RE: Response to Request for Information, Bays 1-4a of the Locomotive Workshop, South Eveleigh (SSD 8517, MOD 7)

Ethos Urban has prepared this letter on behalf of Mirvac Projects Pty Ltd (Mirvac) in response to the Department's Request for Additional Information dated 16 February 2021, which related to the Modification Application (MOD 7) to amend State Significant Development (SSD) Consent SSD 8517 for the adaptive reuse of Bays 1-4a of the Locomotive Workshop and Innovation Plaza at South Eveleigh.

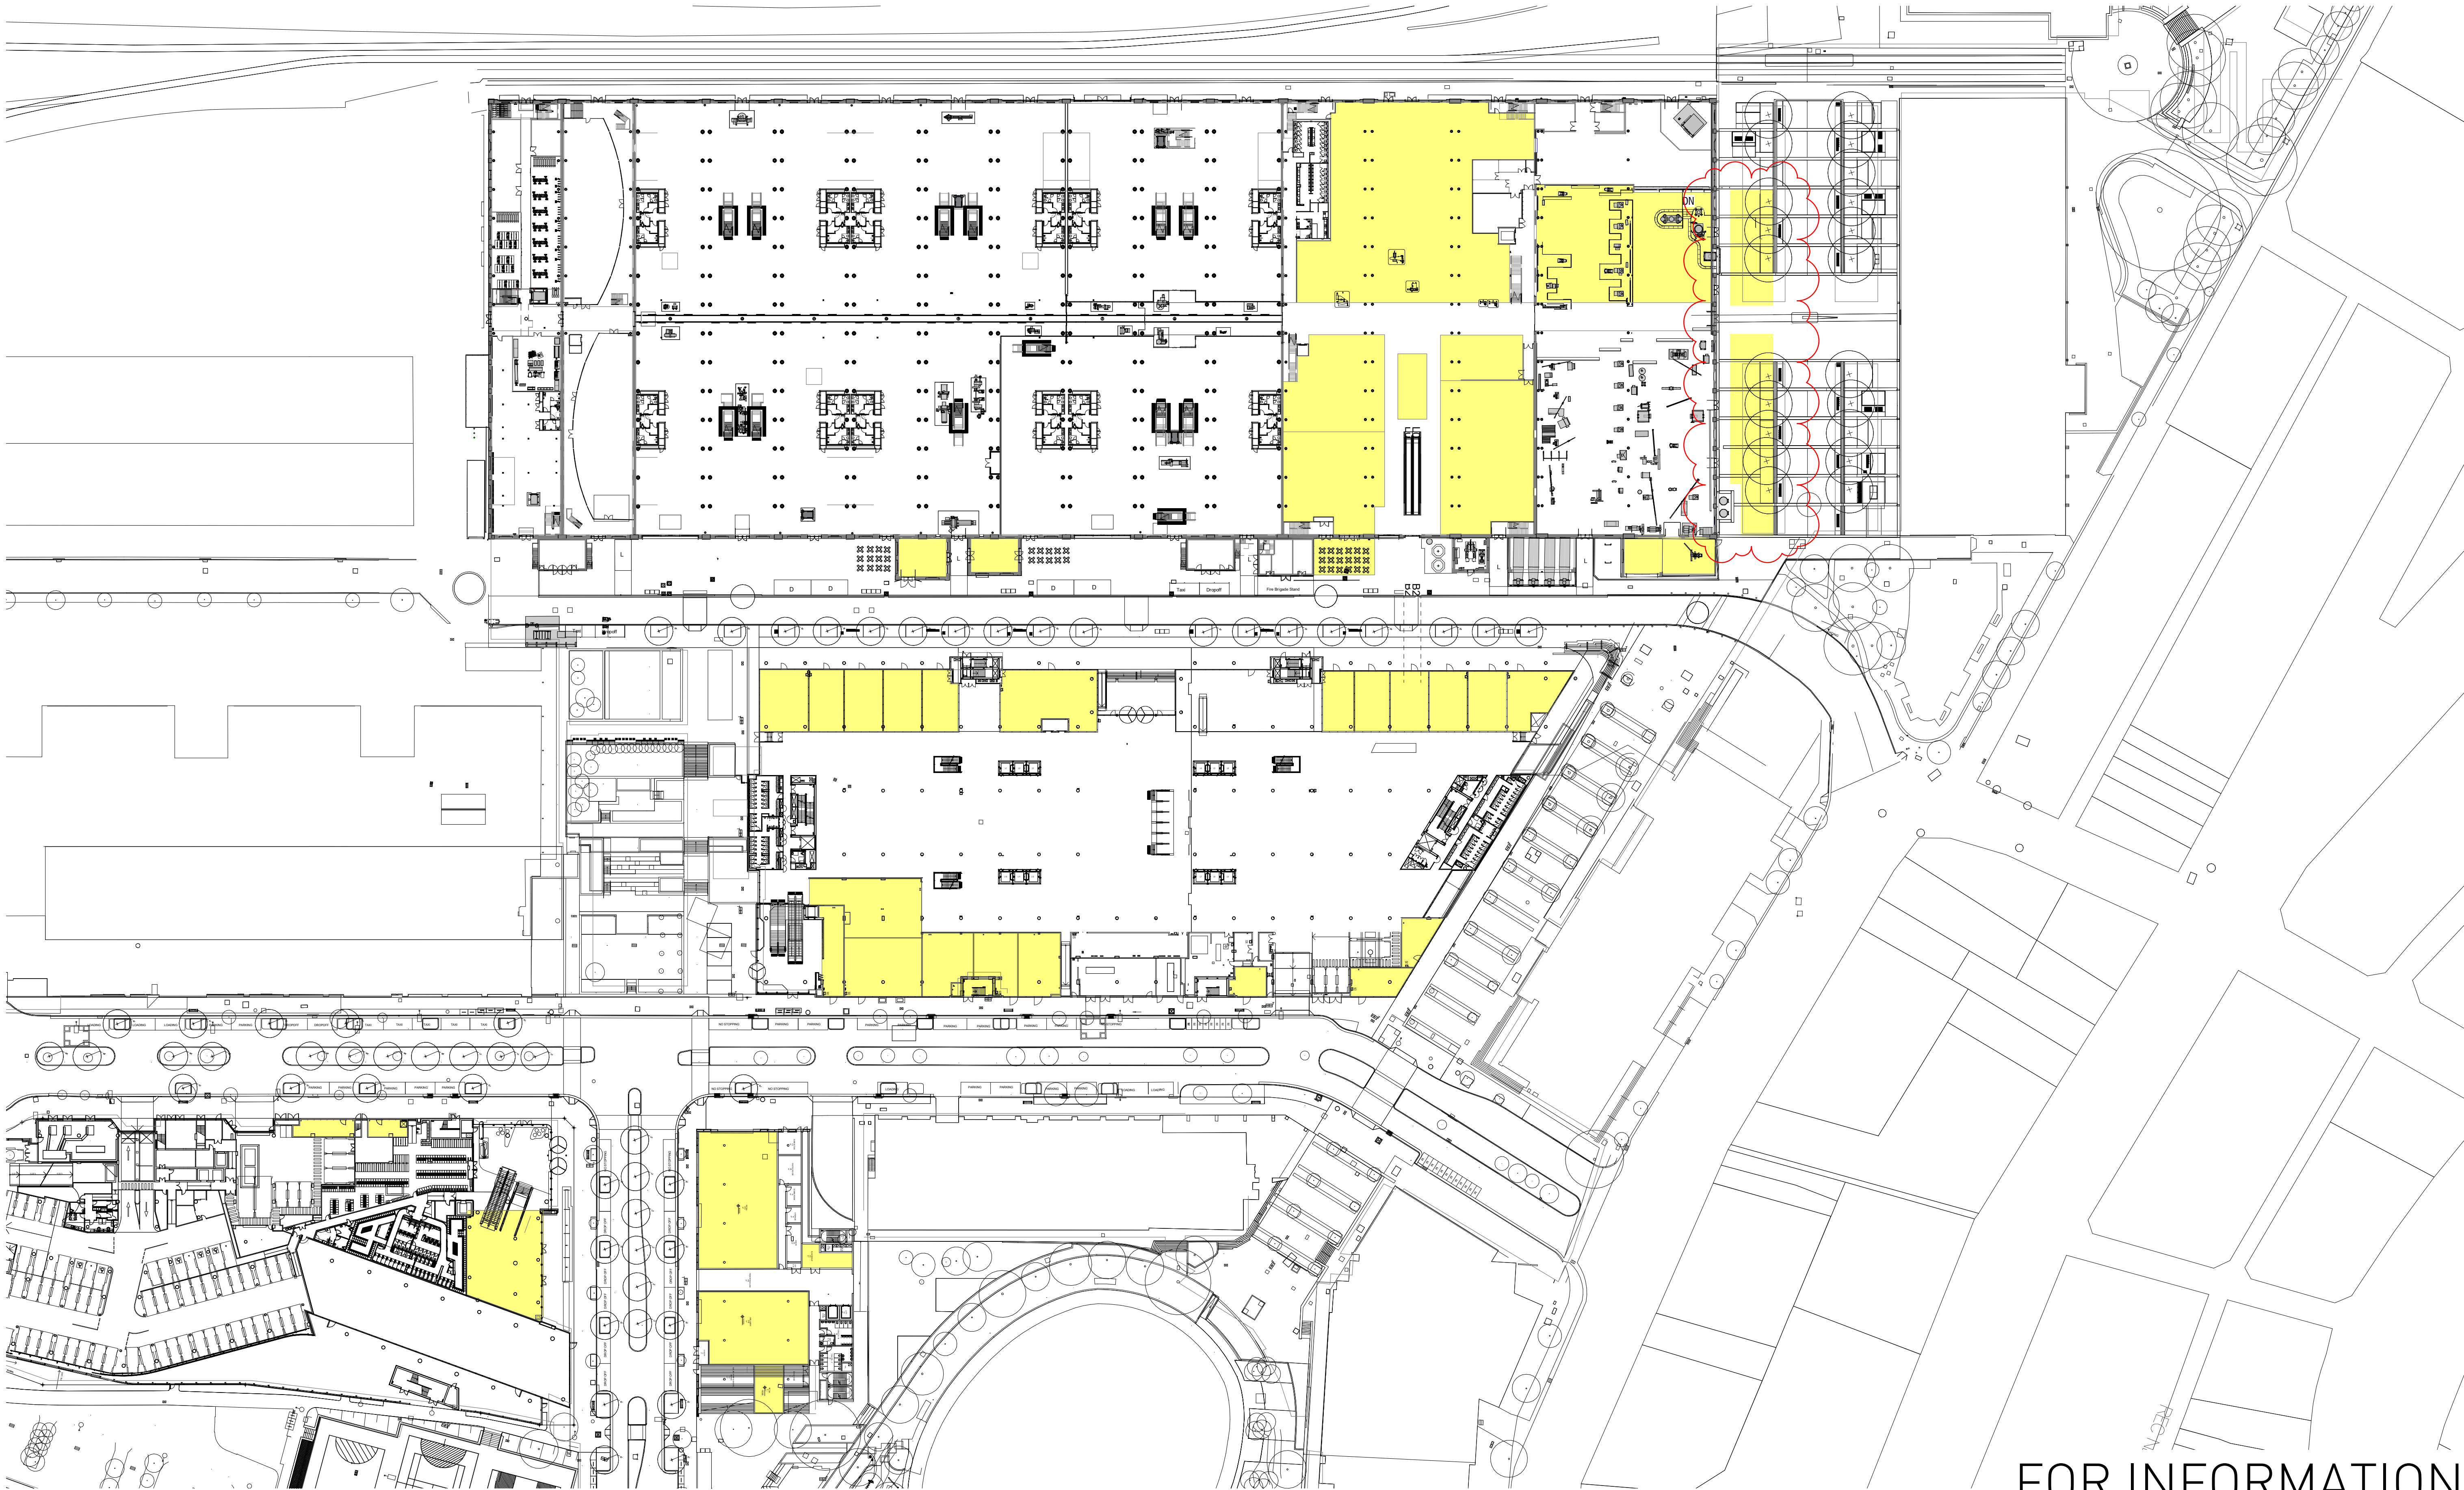
It is recommended that the proposed building envelopes be reconsidered, noting the public recreation zoning, heritage values of Innovation Plaza and the concerns raised by Heritage NSW and Council about the introduction of permanent built structures within Innovation Plaza.

Options should be explored to increase the width of the continuous path of travel between the Locomotive Workshop and outdoor seating zones, to improve pedestrian movement and provide appropriate separation between the outdoor seating area and the Locomotive Workshop.

To ensure the vitality and safety of the community and public domain is achieved, the City recommends that the provision of tenant outdoor seating zones located 1.6m from the Locomotive Workshop building line and outside of the proposed enveloped be deleted. This would allow for a generous width of travel to avoid crowding and increase the safety of people, particularly with impaired visions, to easily traverse and navigate this space.

The revised Architectural Plans included at **Attachment A** and in **Figures 2 and 4** below demonstrate that only one structure zone is now proposed, and the awning structure zone has been removed. It is still intended to provide a bar within the structure zone from which drinks will be served and as such it will be permanently placed in the proposed location, whilst the tenancy is operational. However, the proposed composition is likely to be a container-like structure which will be fully reversible in nature and can easily be removed without leaving any permanent physical or visible traces of it being there, as depicted in **Figure 5**.

The outdoor seating zone are to remain within the revised scheme, as they are considered necessary and critical to activating Innovation Plaza and providing suitable areas for customers to sit and enjoy a drink within the surrounds of the Locomotive Workshops and Innovation Plaza. The width of the outdoor seating zones have been reduced and the path of travel between the Locomotive Workshop and the outdoor seating zone has been increased as discussed above, to provide a 3.2m wide pathway adjacent to the building façade that will enable people to easily traverse and navigate through Innovation Plaza on either side of the outdoor seating zone.
